Job Title: **Lineside Industrial Estate**
Job No: 2017-3548
File Ref: N01-AFG-RSA Stage 2 Designers Response
Date: October 2019

Subject: Stage 2 Road Safety Audit Response

Drawing Title:
**S278 Highway Works
Proposed General Arrangement**

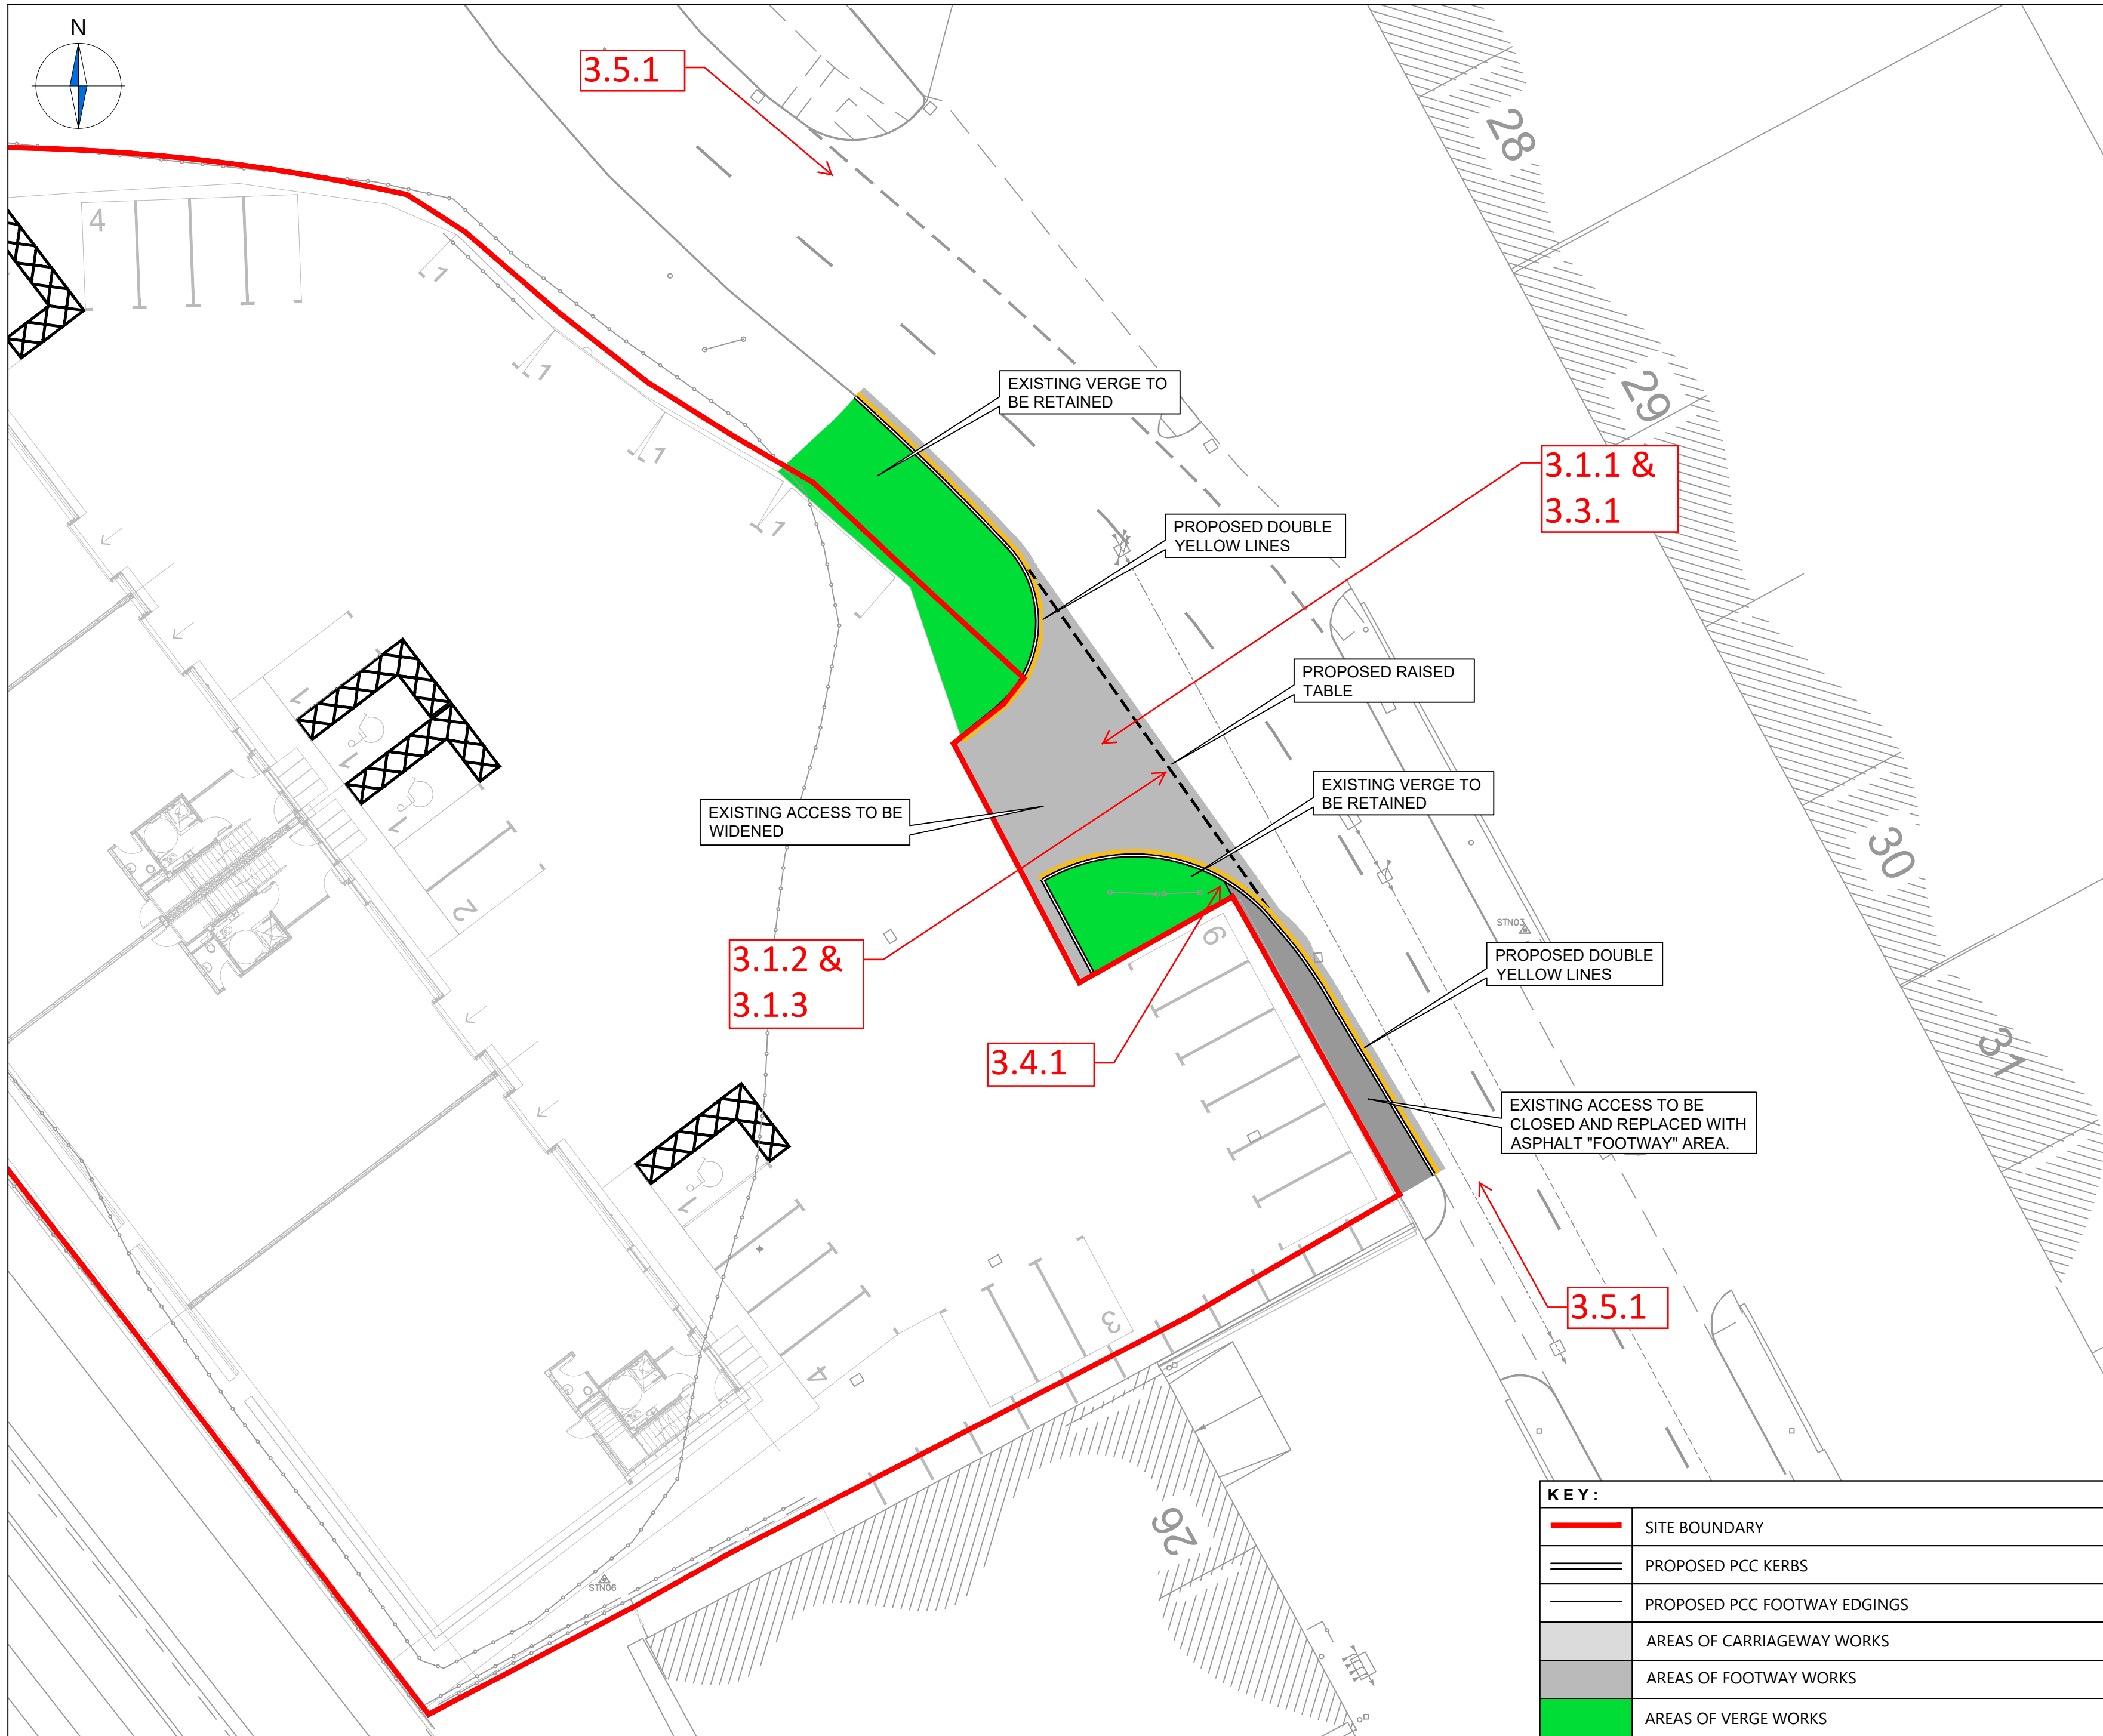
Item Reference	Problem	Recommendation	Designers Response
3.1.1	Location: Proposed access with Eldon Way. Summary: Insufficient construction details could compromise road safety. Construction details were provided for assessment; however, these did not include the Polished Stone Value (PSV) of the carriageway surface. A low PSV could lead to differential braking or overshoot collisions, particularly under severe braking conditions, though it is recognised that vehicle speeds will likely be low.	It is recommended that PSV details should be checked to ensure they provide adequate grip resistance for the speed of road.	Noted PSV values are in-keeping with local road network and to standard, as mentioned in drawing CA_3548_SD04 – Full Depth Carriageway Construction Standard Detail. Within this drawing, the drawing mentions the PSV values being to DfT / Specification for Highway Works, Appendix / Table 7/1.

3.1.2	Location: Proposed ramp to raised table. Summary: Ponding could lead to loss of control collisions. A raised table is proposed; however, the ramp may be a barrier to surface water drainage and could lead to the creation of a low spot. A low spot could lead to ponding and possible loss of control of collisions, particularly in wet or icy conditions, though it is recognised that vehicle speeds are likely to be very low.	That suitable drainage should be provided.	Noted Site changed on design drawings to no longer have a raised table. Entry as existing arrangement now and thus drainage as existing.

3.1.3	Location: Proposed ramp to raised table. Summary: Insufficient construction detail on raised tables could lead to loss of control collisions. No details of the ramp profiles or height of humps have been provided for assessment. There is concern that if the height is outside normal ranges, this could lead to loss of control collisions, though it is recognised that vehicle speeds are likely to be very low.	That ramp profiles should be within normal accepted ranges.	Noted Site changed on design drawings to no longer have a raised table. Entry as existing arrangement now.

3.3.1	Location: Proposed access with Eldon Way. Summary: Insufficient carriageway space could lead to head on collisions or side swipe collisions.	It is recommended that the junction radii should be eased to provide sufficient carriageway space for all expected movements. It is also recommended that the hedgerow should be cut back and that a 'Side road ahead' sign to Diagram 506.1 should be installed on the approach to the junction.	Disagree The access is viewed as a car park, rather than a side road and therefore any issues surrounding a side road are muted. The hedgerows are part of West Sussex

It is noted that 'At any time' waiting restrictions have been provided on the western side of the carriageway, each side of the access, and within the bell mouth of the access. However, the swept paths provided show that the larger vehicles enter the opposing running lane when egressing the access, which could lead to head on collisions or side swipe collisions. Further, the junction follows a sweeping bend, where the junction for southbound traffic may not be sufficiently visible, see figure 1 below, where forward visibility may be impeded by a hedgerow and tree trunk. A lack of forward visibility and warning of the junction could lead to head on collisions or rear end shunts.		County Council's ownership and will require cutting back as part of their works. Additionally, the access exists already and will be slightly widened to accommodate larger vehicles – thus increasing visibility and allowing more movements.

3.4.1	Location: Proposed access with Eldon Way. Summary: Lack of facilities could compromise pedestrian safety The footway on the south side of the access is shown as ending at the access. There is a concern that this will result in pedestrians entering and exiting the site having to walk within the access thereby risking conflict with vehicles, though it is recognised that vehicle speeds will likely be low.	It is recommended that a safer arrangement for pedestrians entering and leaving the site should be provided.	Disagree The site is only accessible by vehicle, with the footway being limited. The asphalt at the front of the site is not viewed as footway due to the footway not leading anywhere (i.e. there is grass verge on the north-west side).

3.5.1	Location: Proposed access with Eldon Way. Summary: Insufficient warning of raised table may lead to loss of control collisions or rear end shunts. No warning signs have been proposed in advance of the raised table at the access. Insufficient warning of the raised table could lead to possible loss of control collisions or sudden braking and rear end shunts and be a particular problem for powered two-wheel riders.	It is recommended that 'Road hump' signs, to diagram 557.1 should be installed on the approaches to the raised table. It is also recommended that triangular warning markings to diagram 1062 should be installed on the ramps of the raised table.	Noted Site changed on design drawings to no longer have a raised table. Entry as existing arrangement now.
